***F.A.O. MS Katie Chew
Your Ref: Planning Application, Bellway Homes Ltd (Yorkshire Division), Land off Woodward Court, Mirfield, planning reference 2015/93355.***

Please find herewith the Save Mirfield response to the above planning application. This document sets out our concerns and objections to the proposed Bellway development of 75 dwellings on Balderstone Hall fields. This represents an increase of 14 homes on the previous application, which was refused. This is the fifth application in relation to this site.

Image 2.3 Proposed Hepworth Lane Site Egress

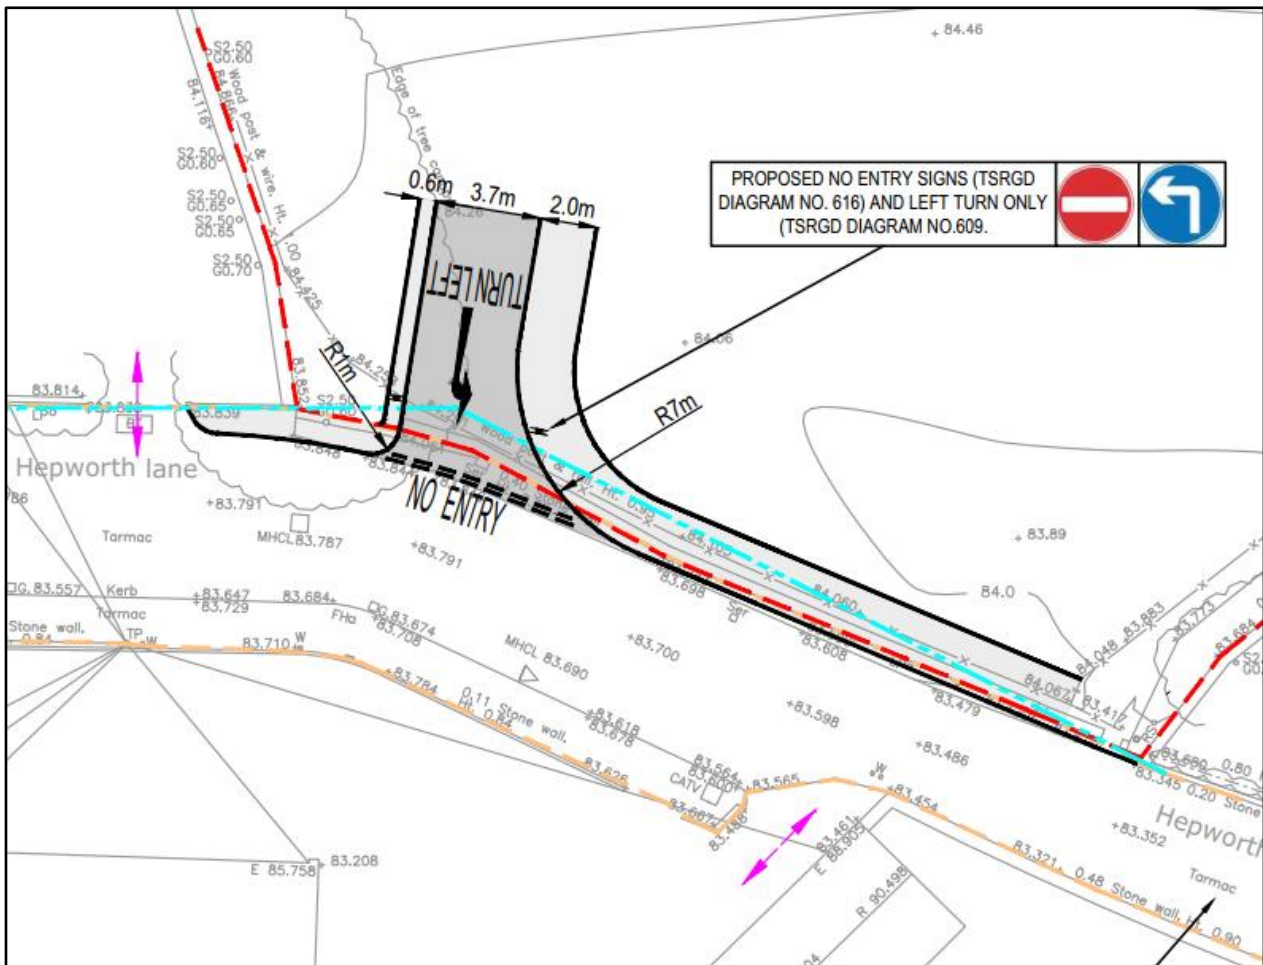
- The second exit into Hepworth Lane which, during the Local Plan (2019) allocations, was assessed as “unsuitable for intensification”, would cause an increase in vehicle movements there and create another even more dangerous location.

The fact that the designers have now added a second exit, albeit without a Public Consultation is important. The eagerness with which they leapt on a few comments from residents who are unlikely to live in the Hepworth area, indicates, in our opinion, that the inadequacy of the Woodward Court access point has been recognised by them (as it was in the application in 2014 by the planning department). Our discussions with residents in the Hepworth Lane area showed us how strongly they feel about the exit proposal. The residents "lived experience" makes them acutely aware of the issues. Had the designers produced the final plan at the Public Consultation they would have had to write a different report. ***This secondary exit creates or worsens another dangerous point on the local highways network.*** As Bellway own the site up to the boundary with Hepworth Lane it was relatively simple for them to make the exit there. ***However, they failed to identify that Hepworth Lane at the previous LP hearings was evaluated and determined "unsuitable for intensification".*** Since nothing has changed in Hepworth Lane we believe this is true.

--- 2.4M X 25M JUNCTION VISIBILITY SPLAY BASED ON 20MPH SPEED LIMIT

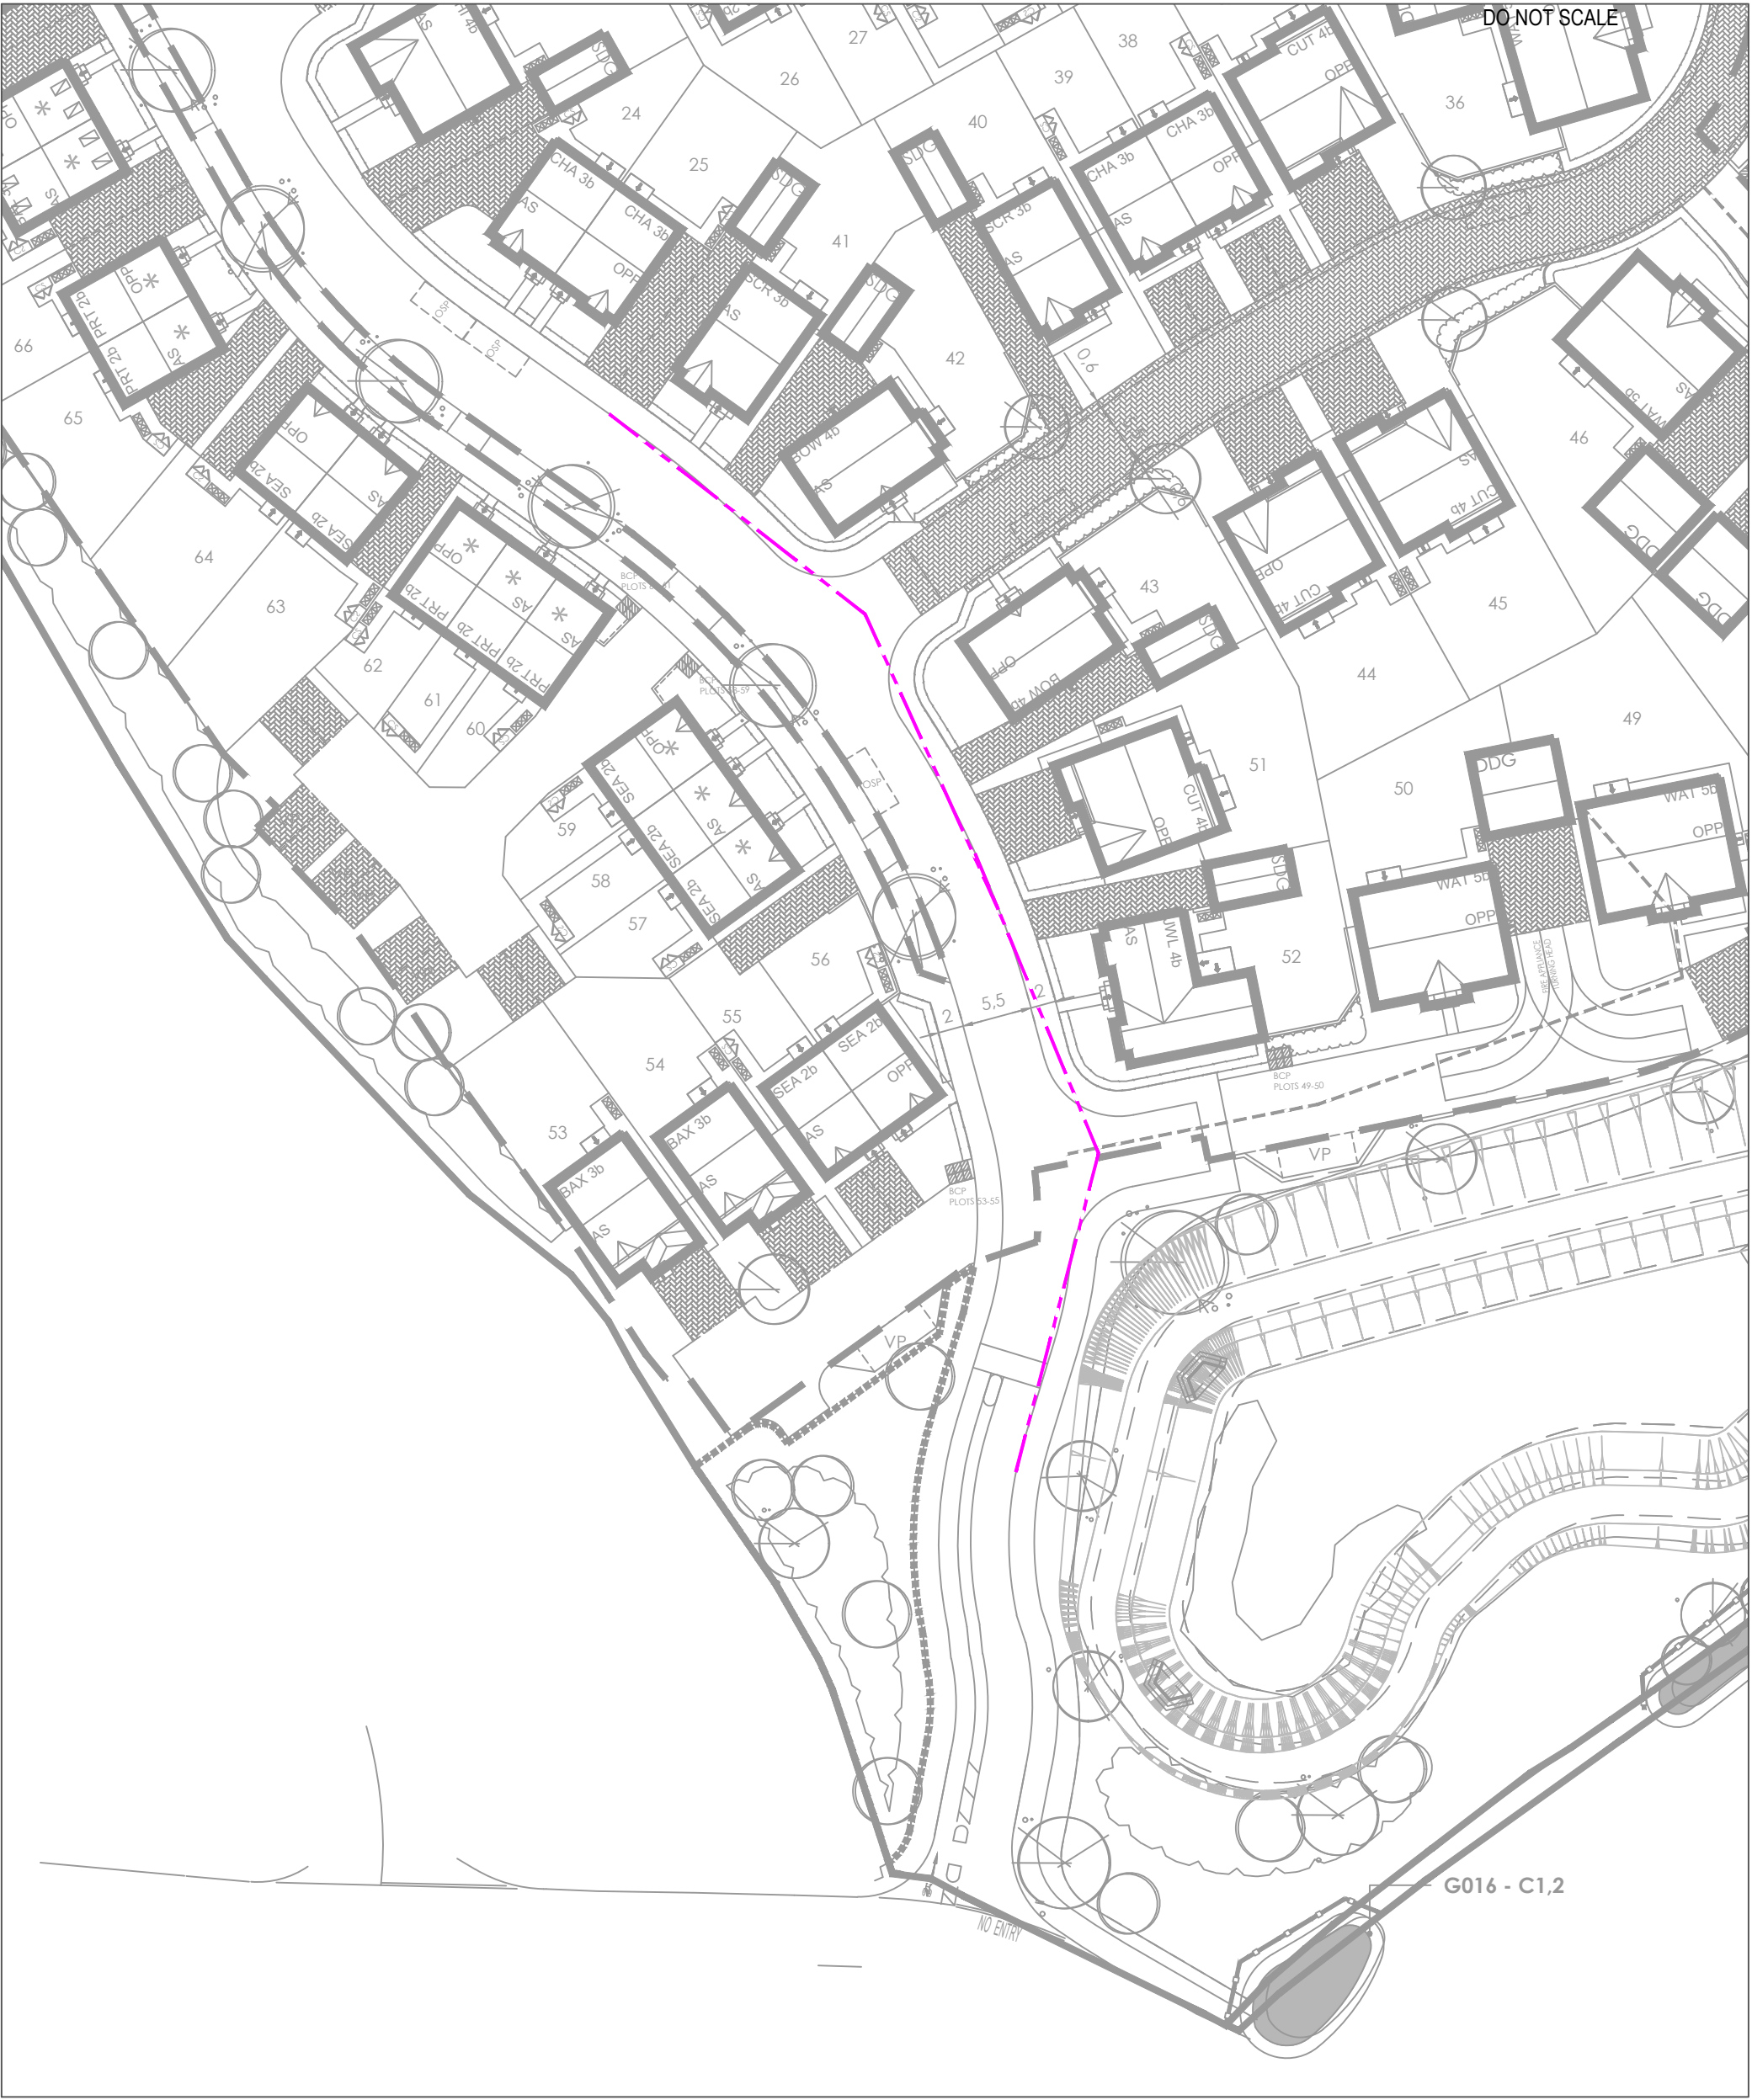
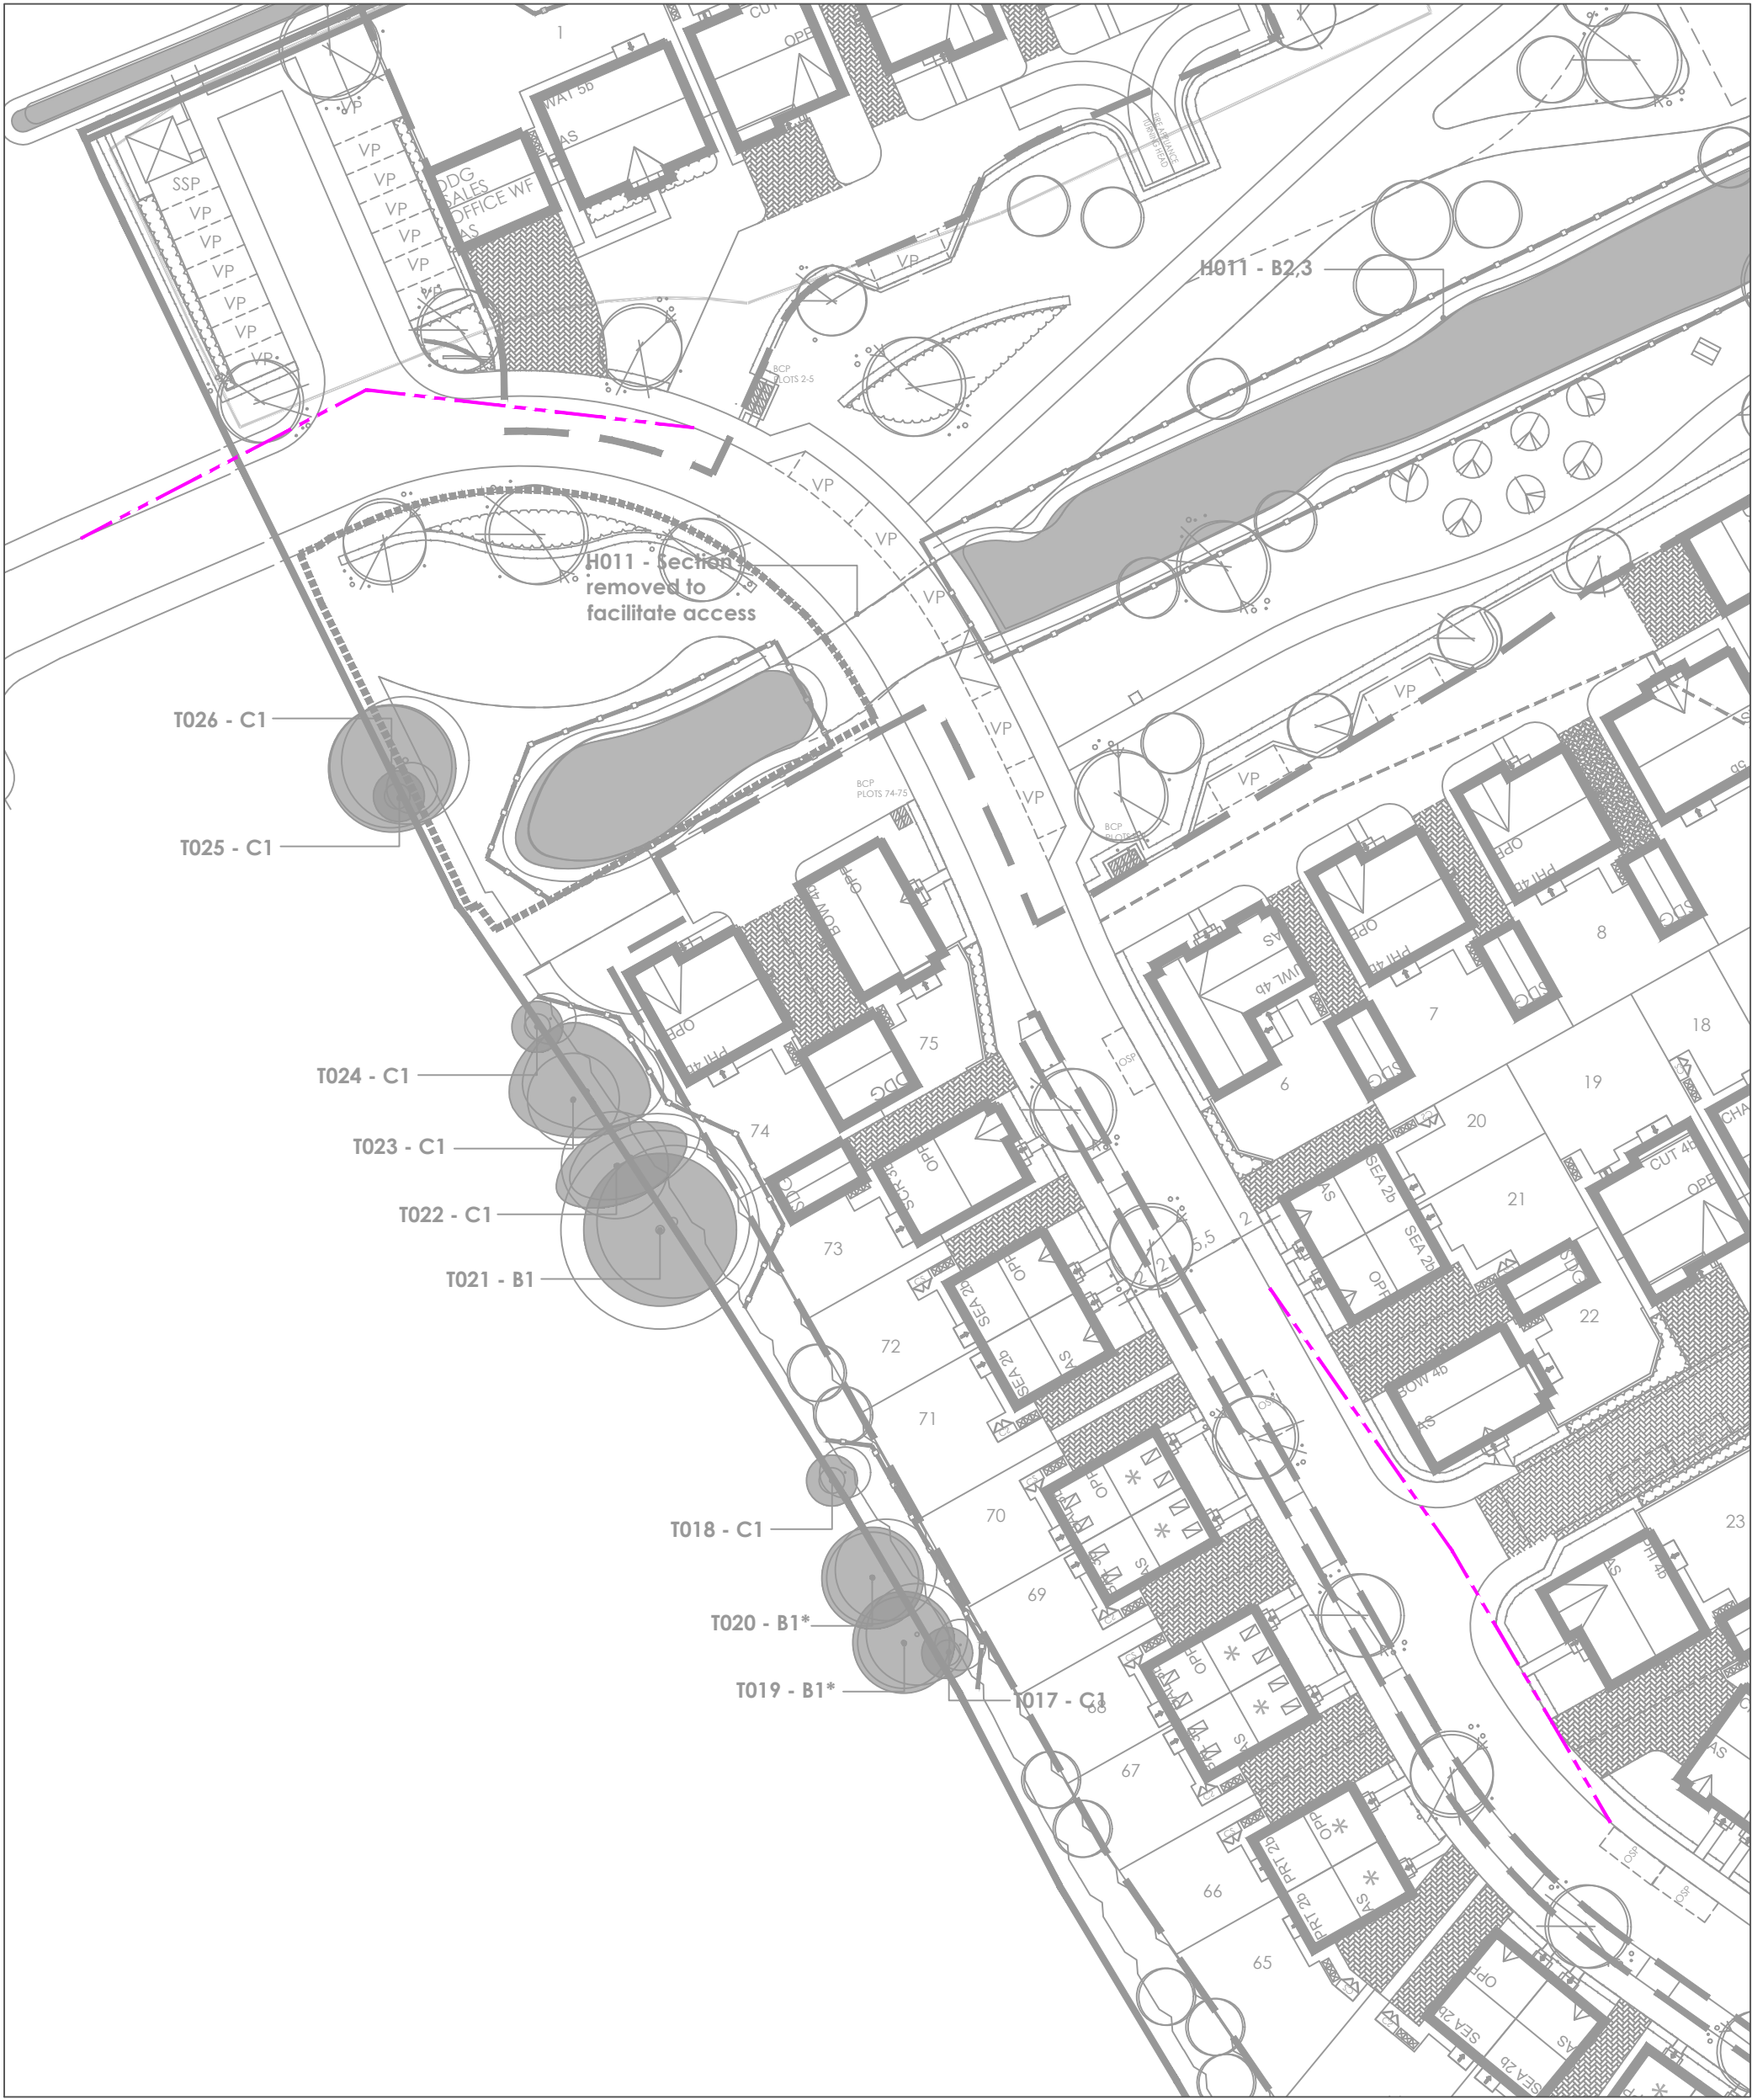
We also note that the visibility splay at Woodward Court shown in the application still does not provide an adequate sight line in spite of the speed mitigation measures proposed.
